DOC17/599447-01
SSD 8647

SSD 8647 – HORNSBY HOSPITAL RE-DEVELOPMENT – ENVIRONMENTAL IMPACT STATEMENT (EIS)

- ENVIRONMENT PROTECTION AUTHORITY COMMENTS – HORNSBY HOSPITAL RE-DEVELOPMENT STAGE 2 EIS

Noise Monitor Along Derby Street: Tuesday 30 May, 2017

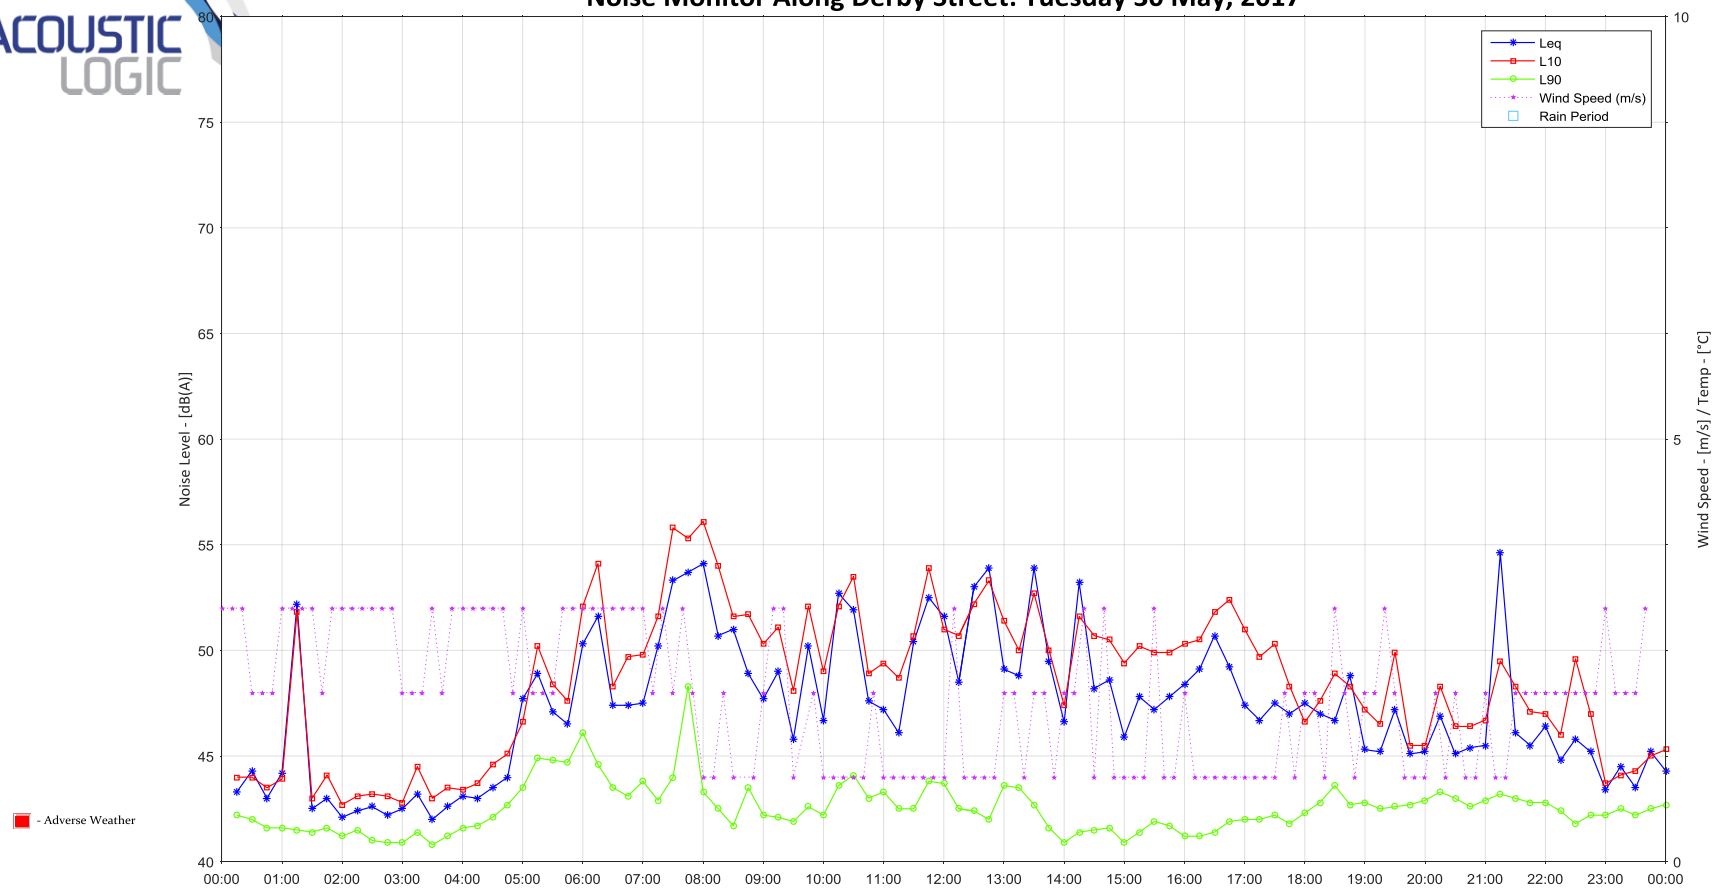
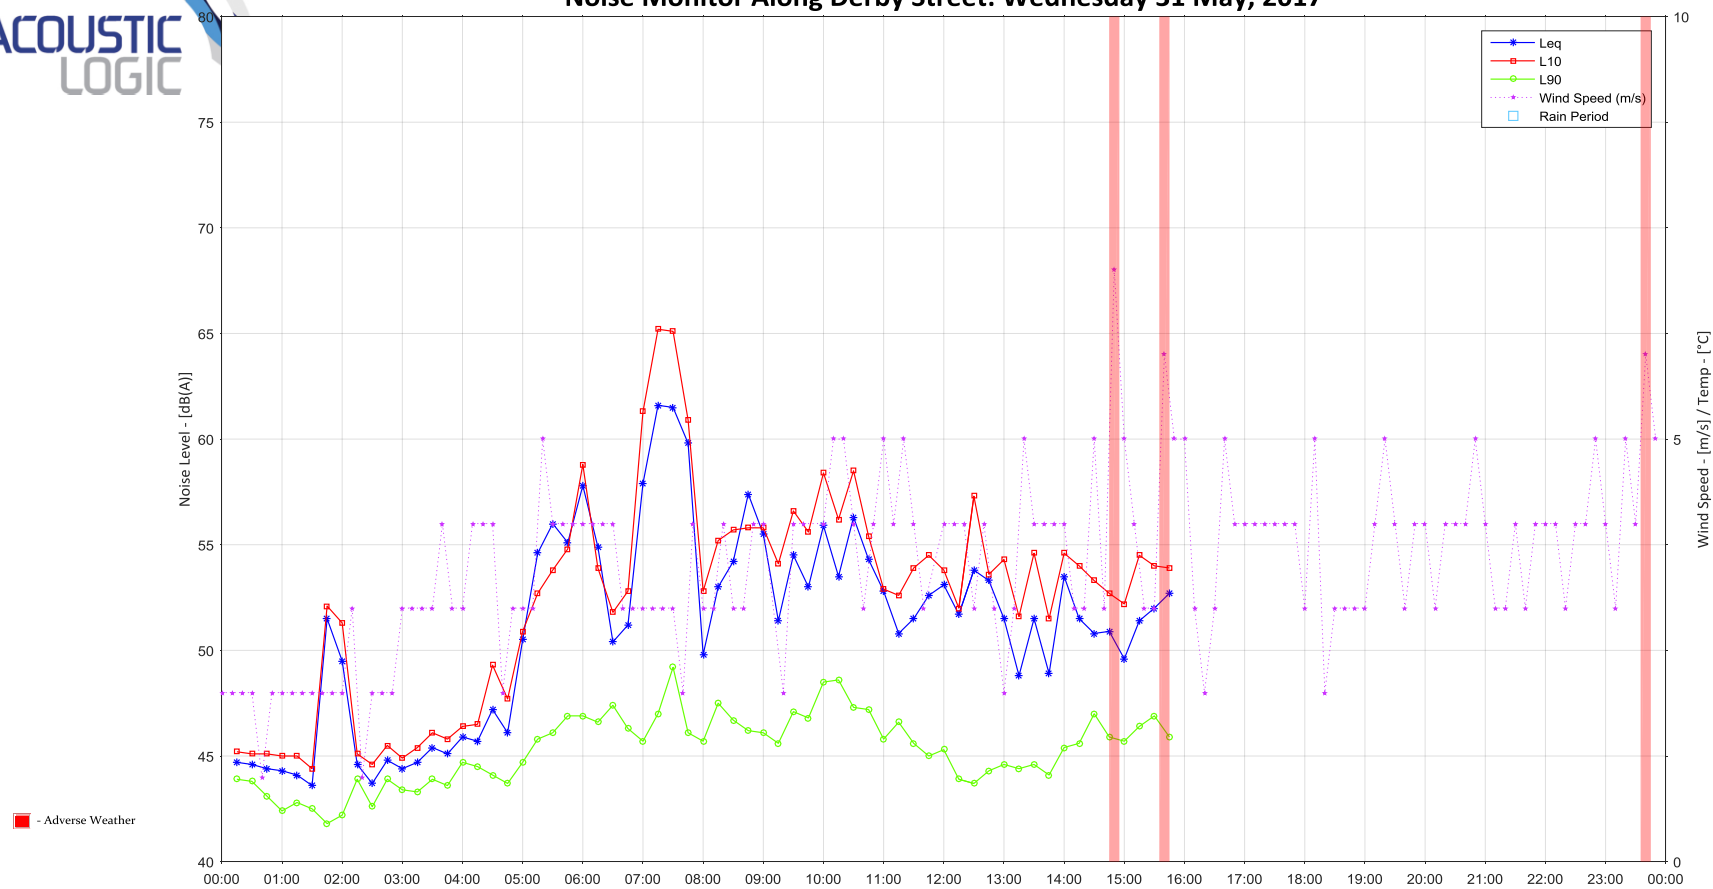
The EPA is concerned that the noise monitoring graphs presented in 'Appendix 2 - Noise Monitoring Along **Derby Street**' to EIS Appendix Q appear instead to be a duplicate of graphs for Burnett Street and thus that the data for Derby Street appears to have been omitted from the EIS.

- (a) the legends to some monitoring graphs appear to be misaligned (e.g. wind speed, rain period),

- (b) the legends to monitoring graphs includes a blue marker for 'rain period' and although rain was observed on several days during the various monitoring periods (i.e. 24 May to 7 June 2017), no rain periods are represented in the graphs, and
- (c) some of the monitoring graphs include sections of red highlight, but there is no red marker in the legend to those graphs to identify the meaning of those red highlighted periods, and
- (d) Appendix Q does not appear to identify when noise monitoring loggers were last laboratory calibrated which brings into question reliability of the recorded data.

- (a) the equivalent of a week's worth of valid data, measured at the potentially most affected noise sensitive receiver locations in Burdett Street, Derby Street and Palmertson Road; and
- (b) the results of attended monitoring, graphical results of unattended monitoring with a complete and accurate legend together with a table of assessment background and daily ambient levels.
